TRANSMITTAL SHEET

To:	City of Mercer Island	From:	Erik Voris
Company:	Department Services – Building & Planning	Project:	Project 2101-202
Address:	9611 SE 36 Street Mercer Island, WA 98040	Date:	6/9/2021
		Regarding:	Correction Cycle#1

In addition to the transmitted documents, please refer to the specific responses to each plan reviewer's correction comments below.

LOWER FLOOR PLAN

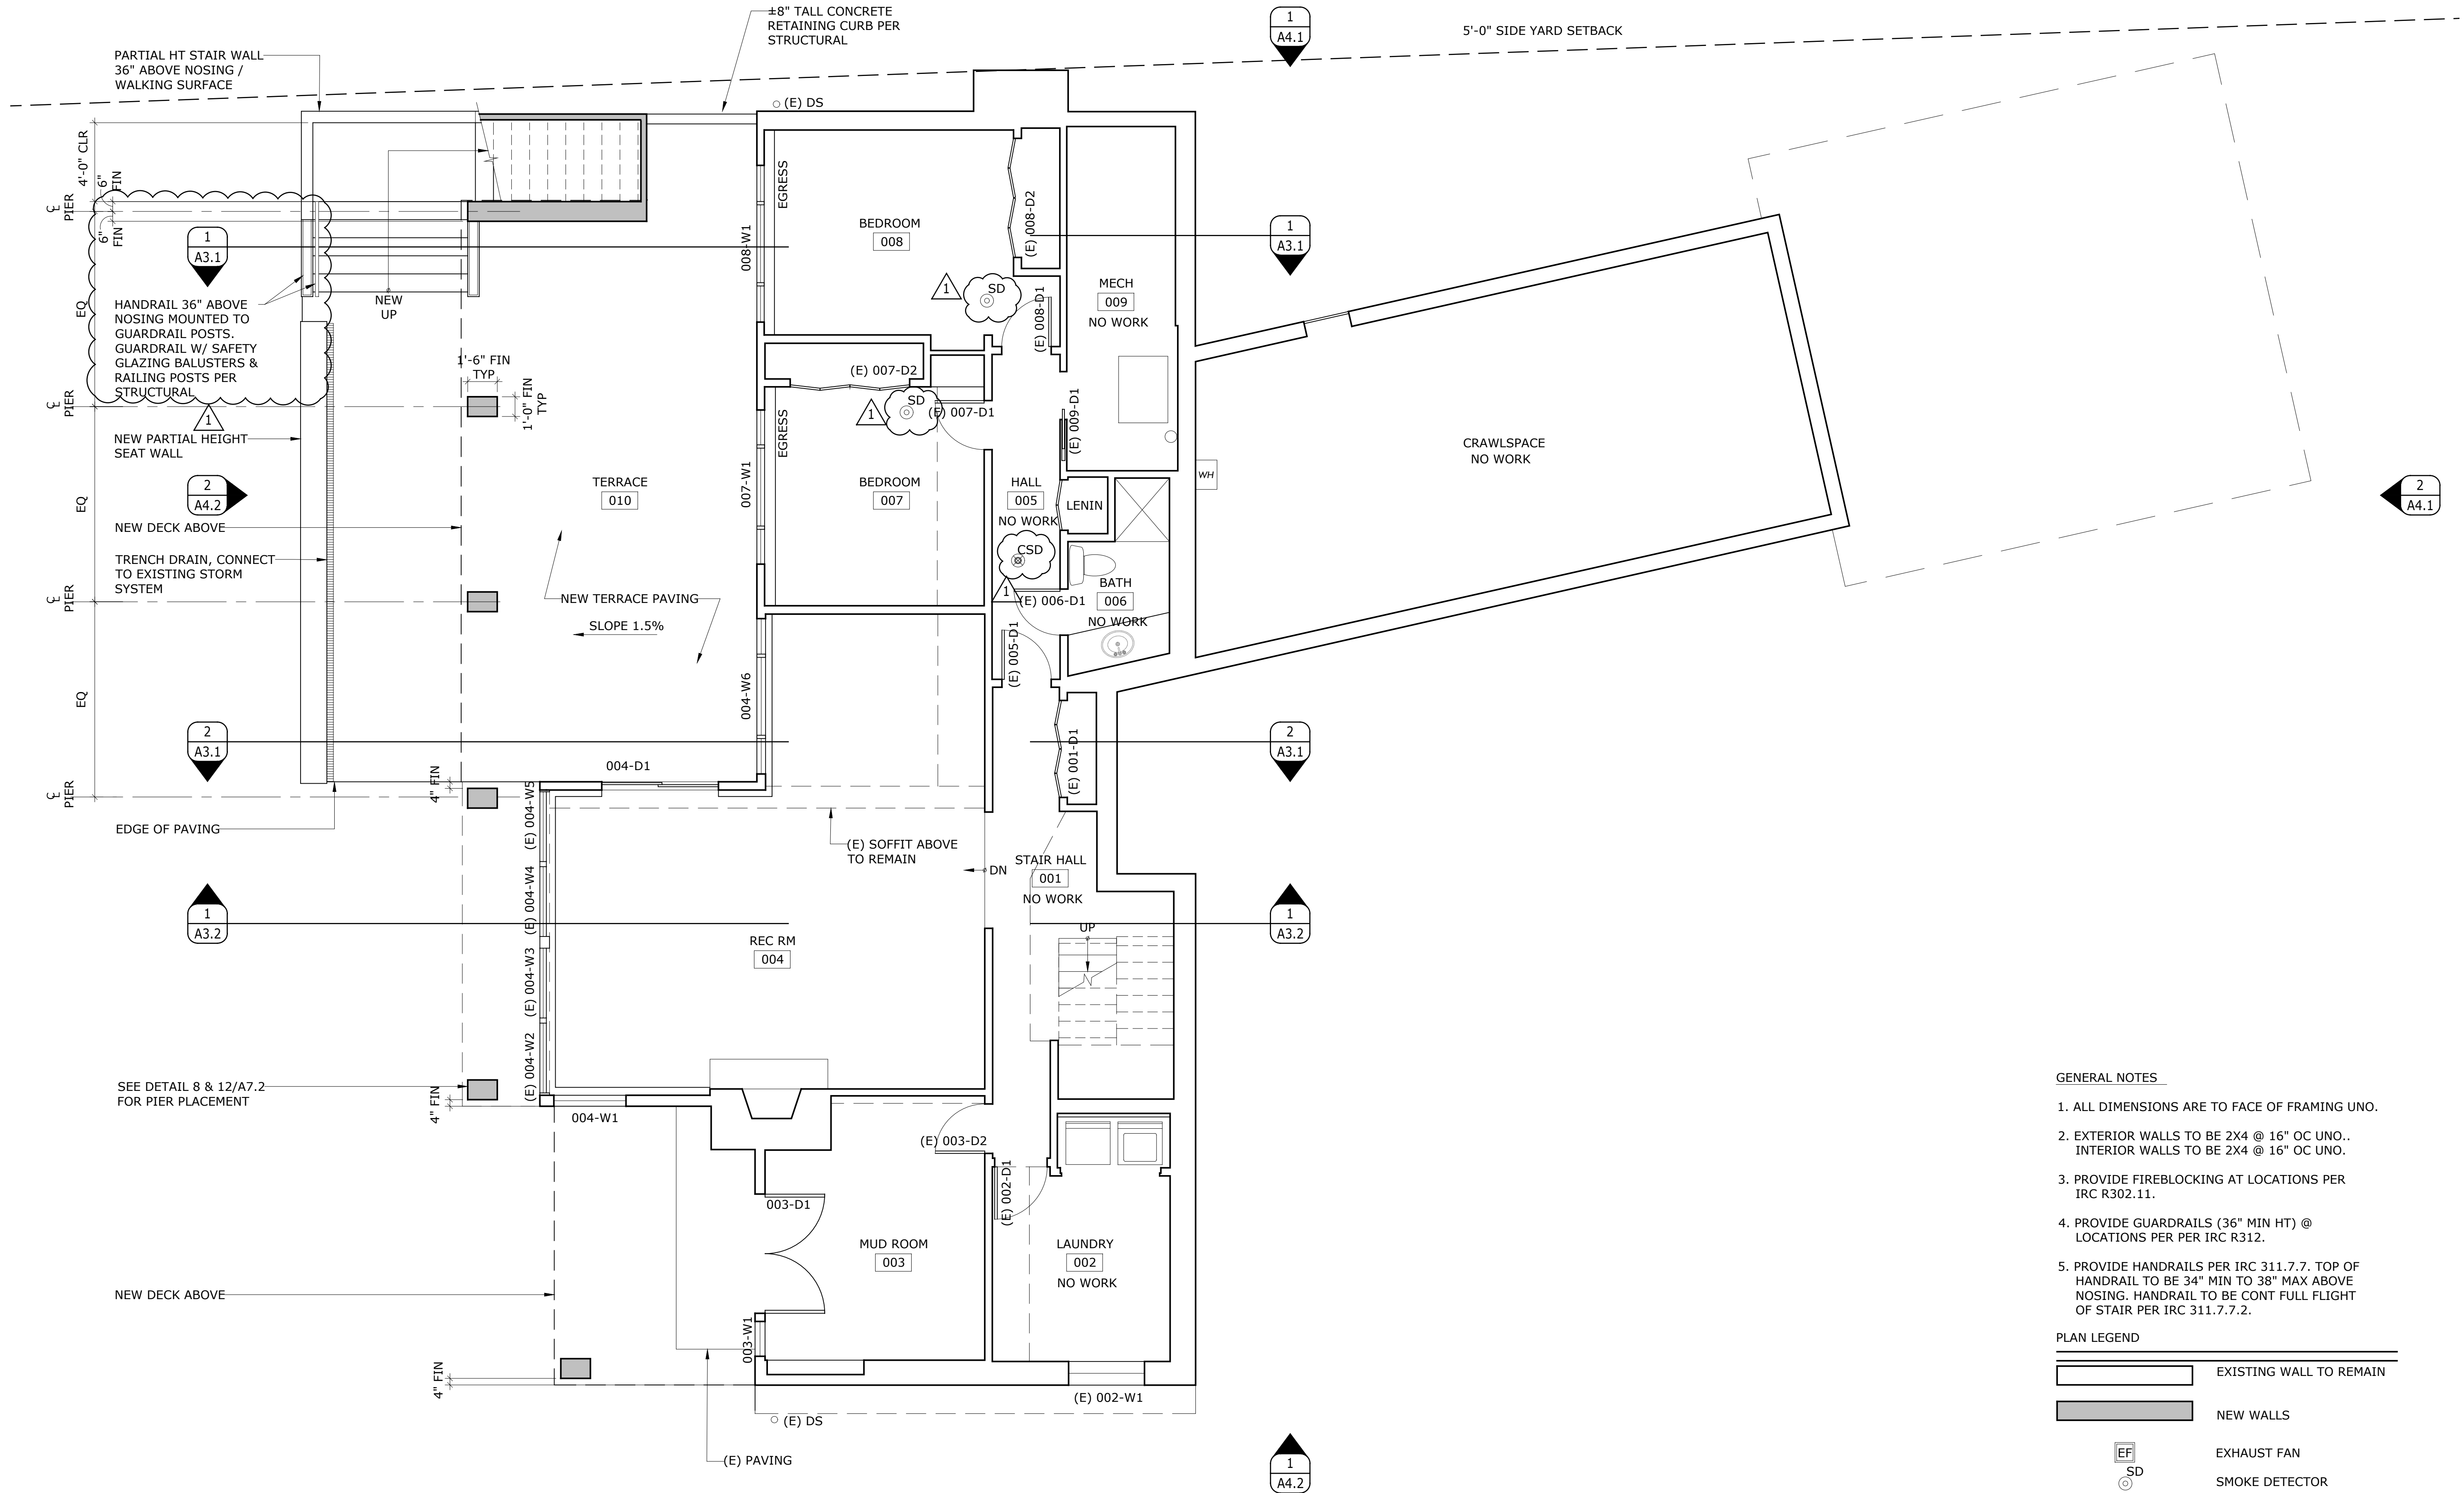
1. The Geotechnical Engineer is required to provide a written statement that the project documents have been reviewed for conformance to the geotechnical recommendations.
2. Please clarify what the elements are that are being removed. Is this a soffit? Wall? Steps?
3. CO detector required outside the bedroom(s).

4. SD required in each room.
5. Handrail? Clearly indicate the extent of the handrail on the plans.
6. If the single (assumed) overflow roof drain is intended to provide overflow drainage for the whole roof deck, please confirm drainage capacity.
7. Note stair rise and run. Confirm that this is a single riser.
8. Provide overflow roof drain this deck.
9. Provide structural framing for upper new roof eave extension.
10. Provide verification the membrane is approved for use as a walking deck and for the installation of the decking material directly on top of the membrane per the International Code Council Evaluation Service (ICC-ES) Roof and Walking Deck Membranes in accordance with the ICC-ES Criteria for Walking decks (AC39).
11. R-30 Minimum.
12. Please coordinate design with the structural design. 11-7/8" deep floor joists?
13. Confirm secondary overflow roof drain has been provided.

- 3 - CO detectors has been shown outside of bedrooms on A2.1 Lower Floor Plan and A2.2 Main Floor Plan.**
- 4 - SD detectors has been shown in bedrooms on A2.1 Lower Floor Plan and A2.2 Main Floor Plan.**
